CITY OF ALBUQUERQUE

August 4, 2017

RE: **Campbell Compound**
Drainage Report and Grading Plan
Engineer's Stamp Date 7/21/17
Hydrology File: G13D032

NOTE:
ALL RETAINING WALLS/FLOODWALLS SHALL BE DESIGNED BY OTHERS. THE DETAILS/SECTIONS SHOWN ON THIS SHEET ONLY DEPICT TOP AND BOTTOM AND MAX. HEIGHTS OF RETAINING WALLS.

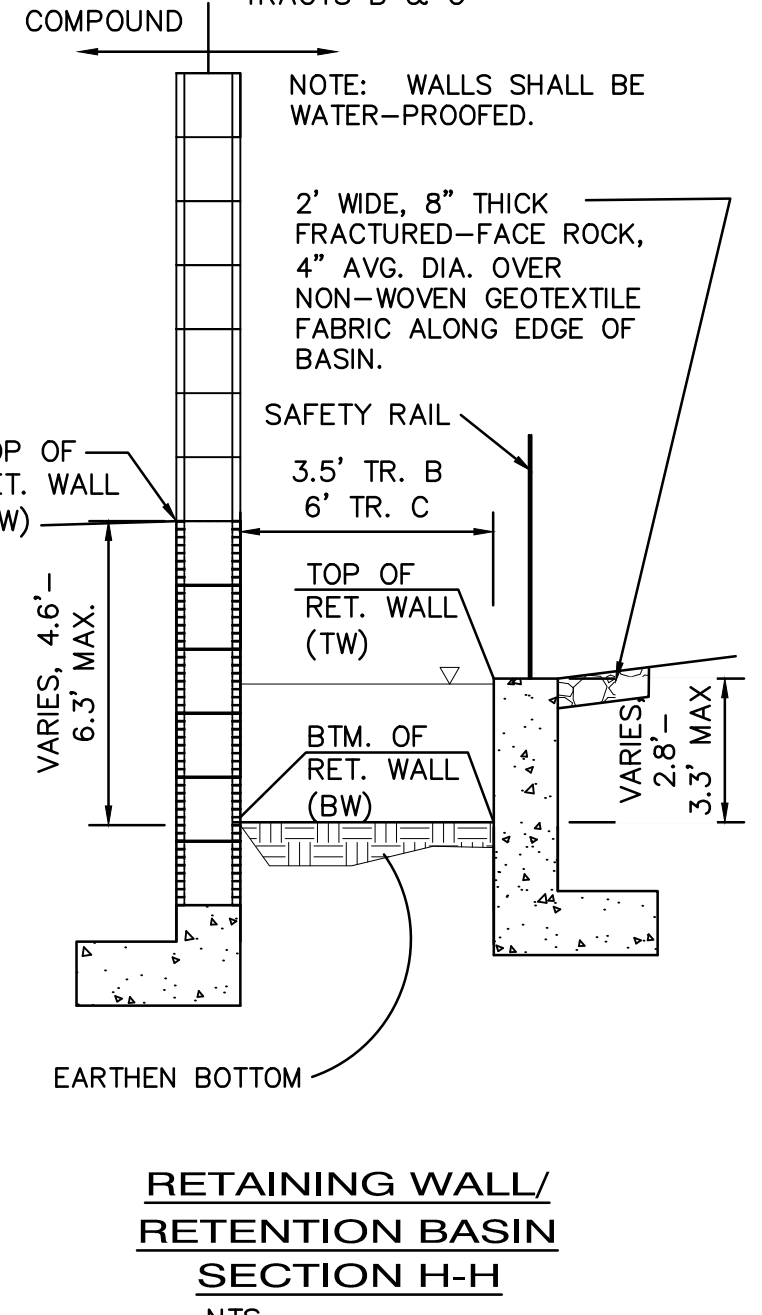
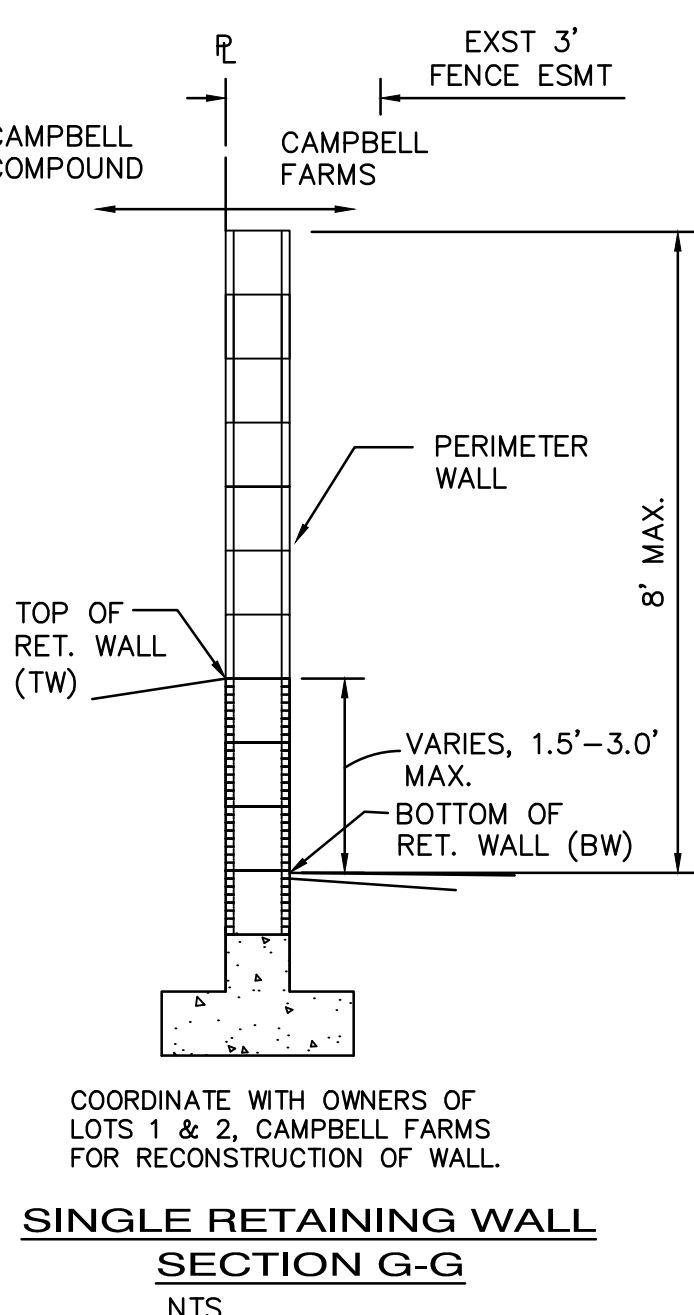
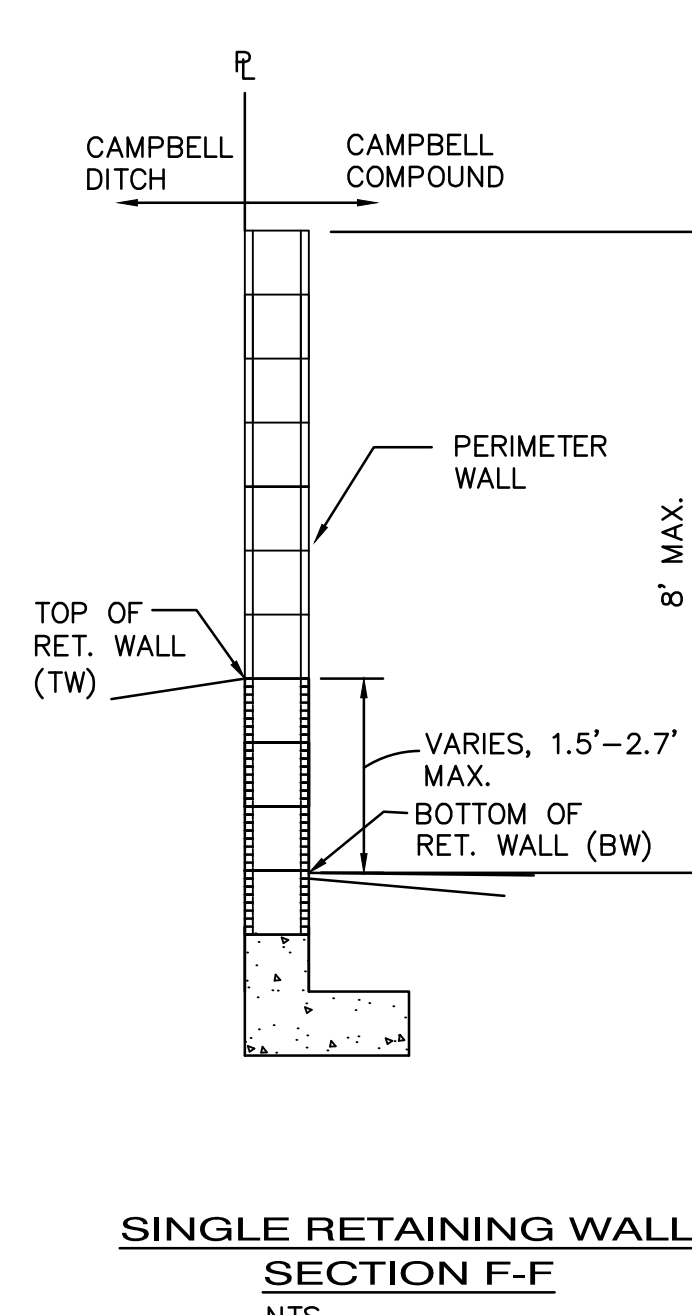
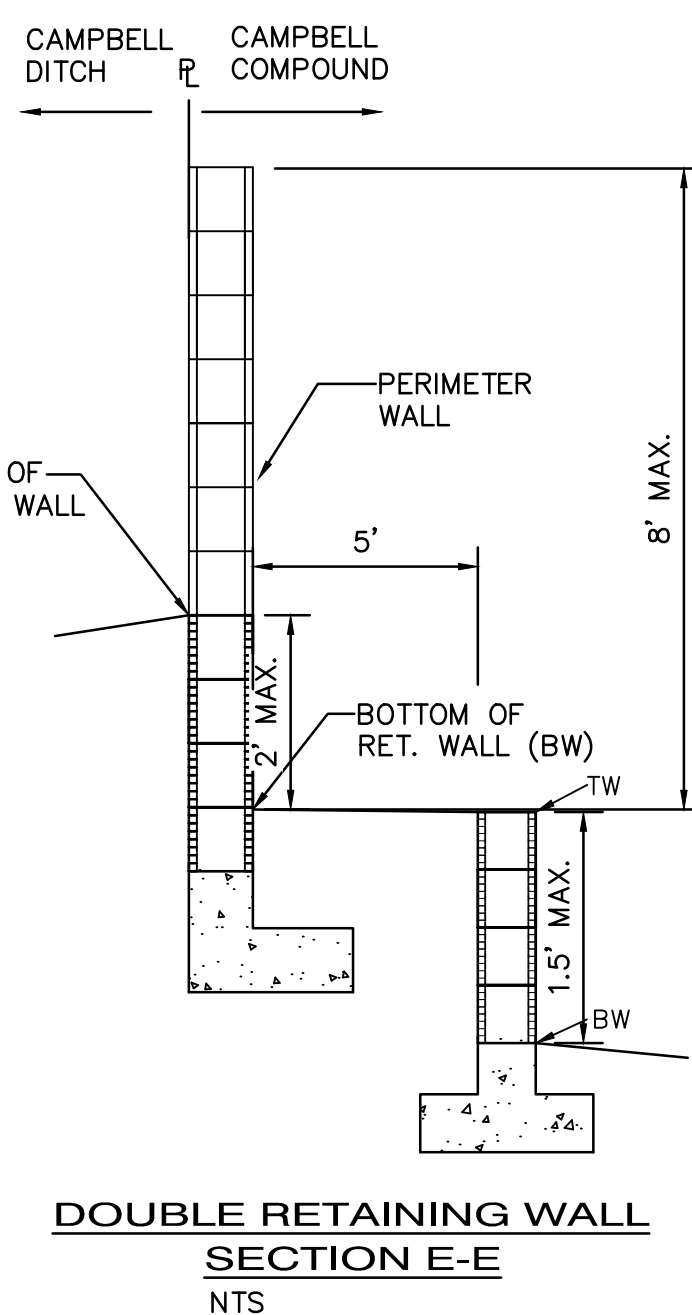
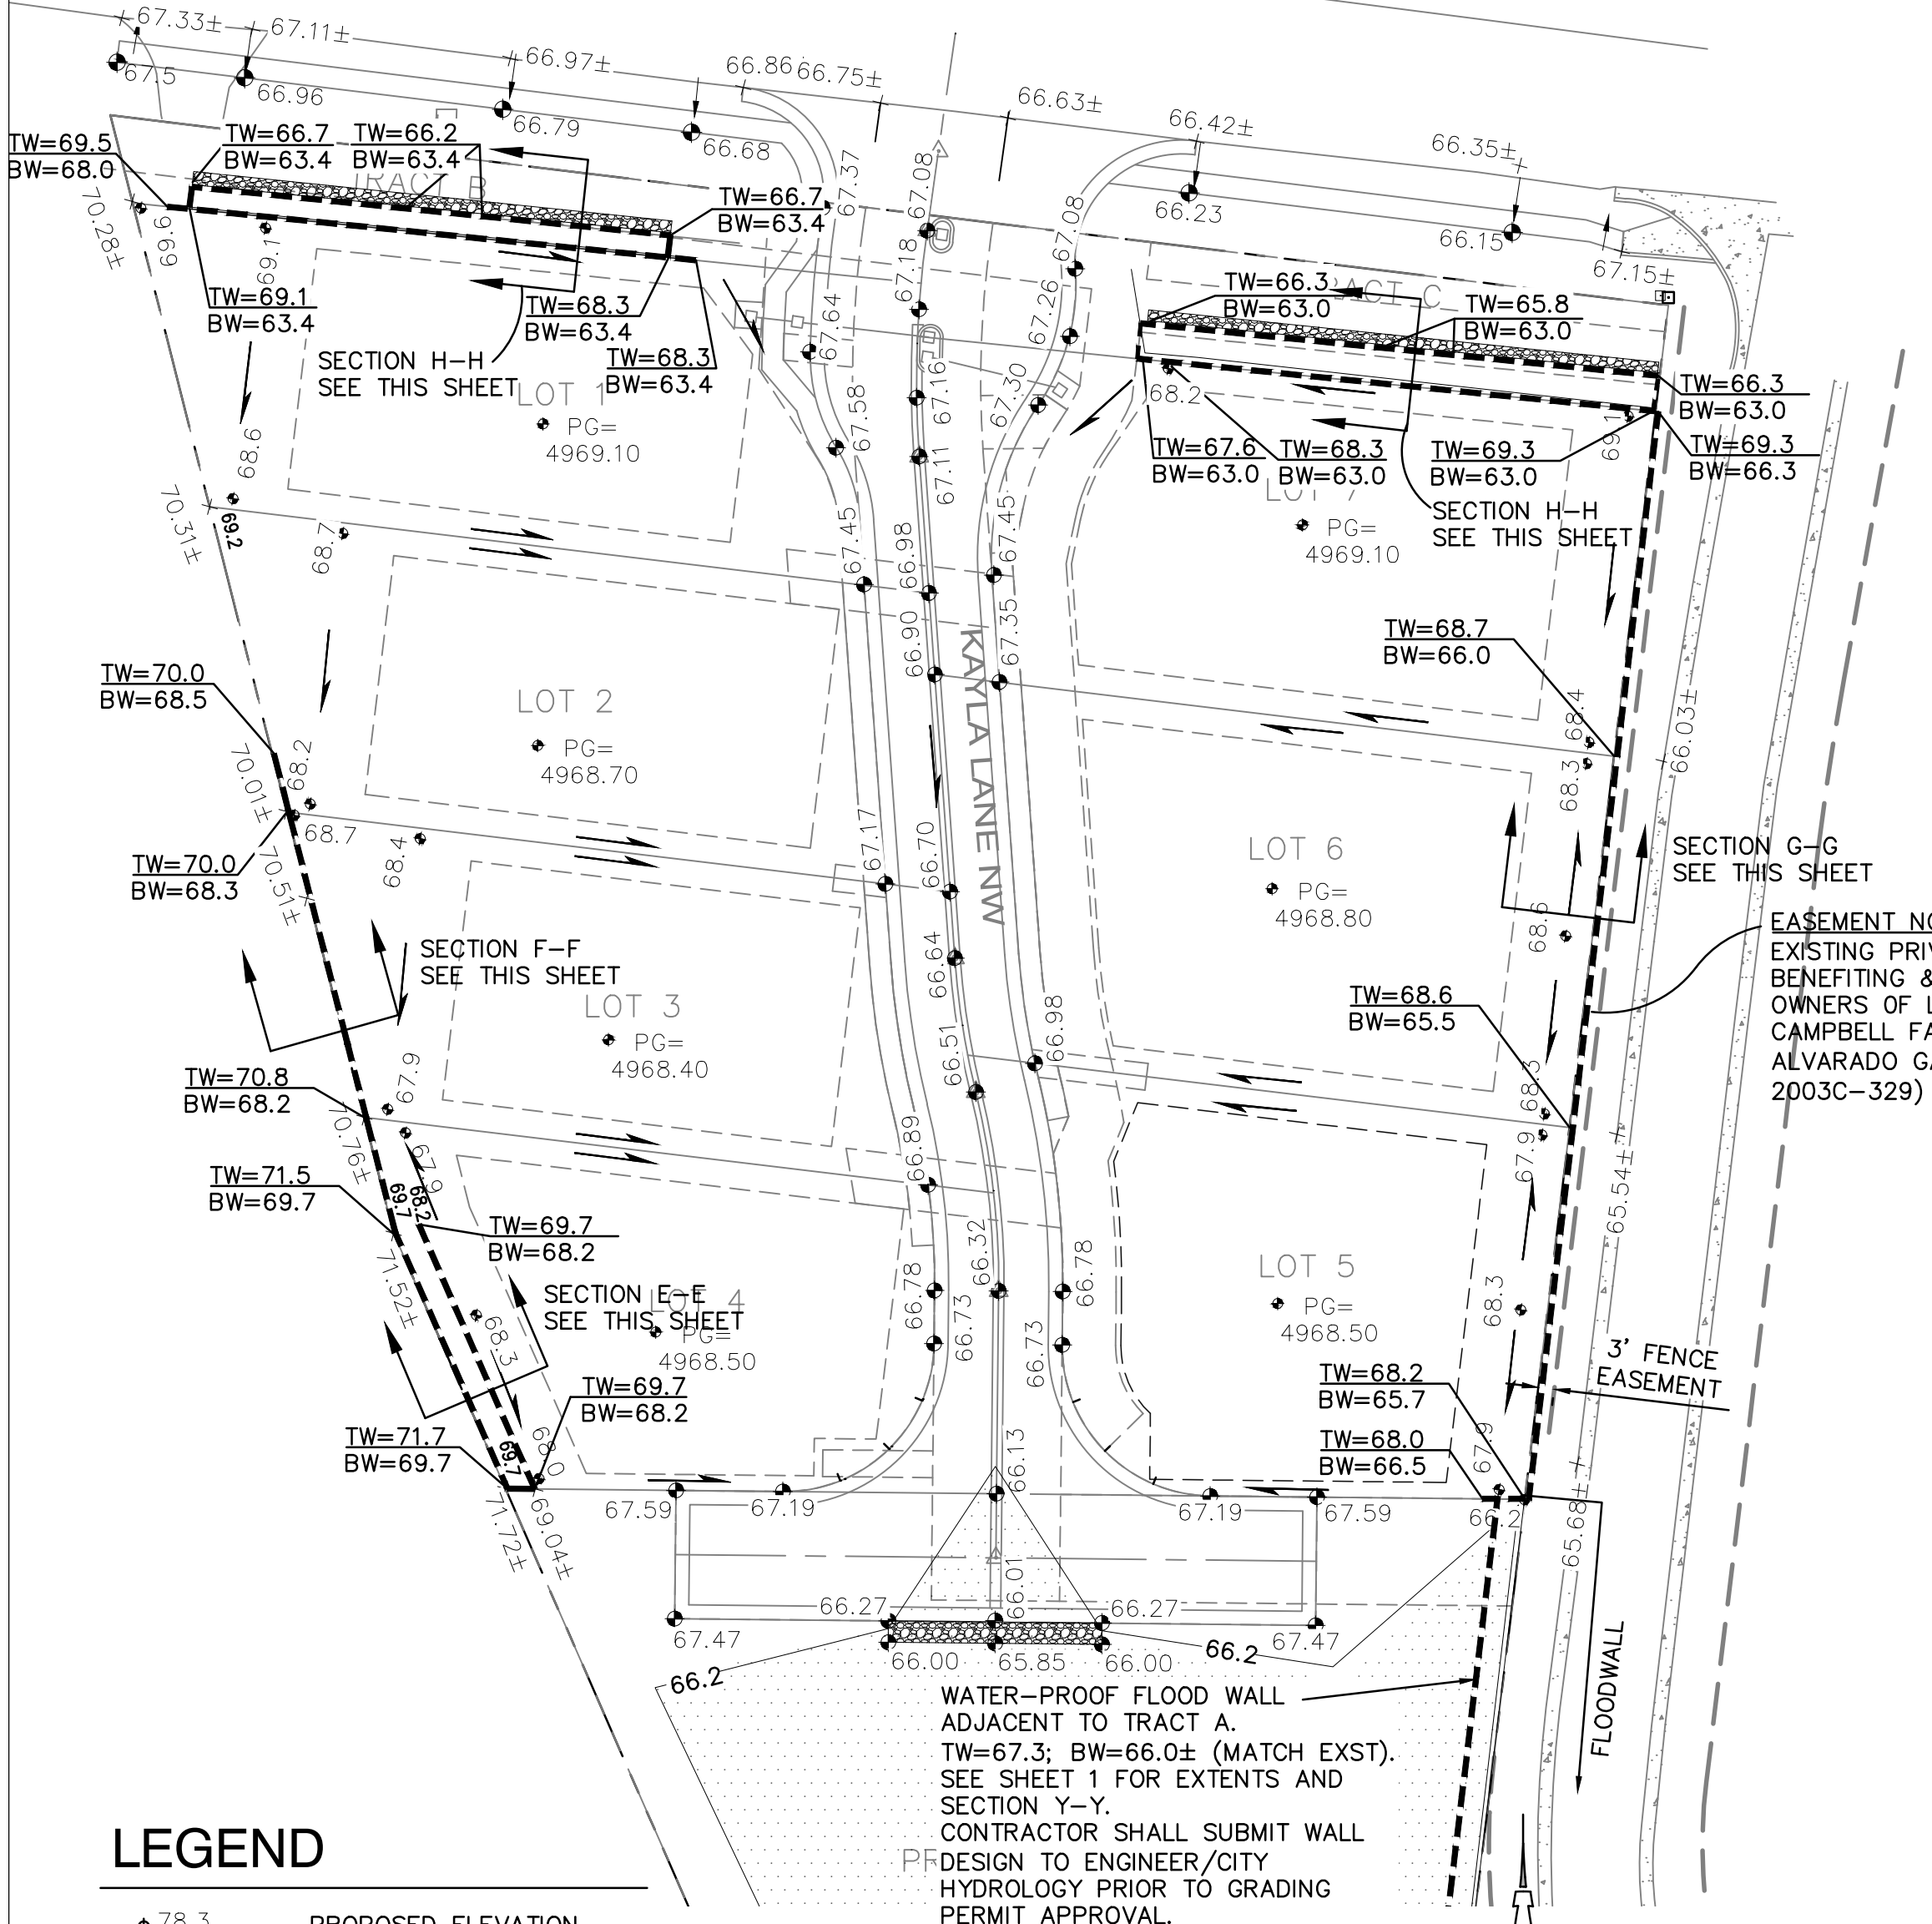
- 6.1. Raising the grade in this subdivision will put it several feet above the Campbell Farms subdivision. Ensure no drainage will exit this project site and impact this adjoining subdivision.
- 6.2. Include a section view though the property line between Campbell Farm Rd and the Campbell Compound east lots.
- 6.3. The backyard walls and footers (Section B-B) will need to be wholly contained on this project's property, unless written concurrence can be provided by the adjoining property owners for common walls.
- 6.4. Show the property line, section cut, and dimensional data for the double retaining wall.
- 6.5. Provide additional dimensions on the wall sections: max height retained, max privacy wall heights, and offsets.

- 6.6. Increase the slope and specify a minimum depth at flowline along the backyard walls; clarify the typical lot grading detail to show the backyard drains to the front (Kayla Ln) and no cross lot drainage or drainage through the backyard wall occurs.
7. Are any easements required for the ditch and will they conflict with the pad or wall locations?
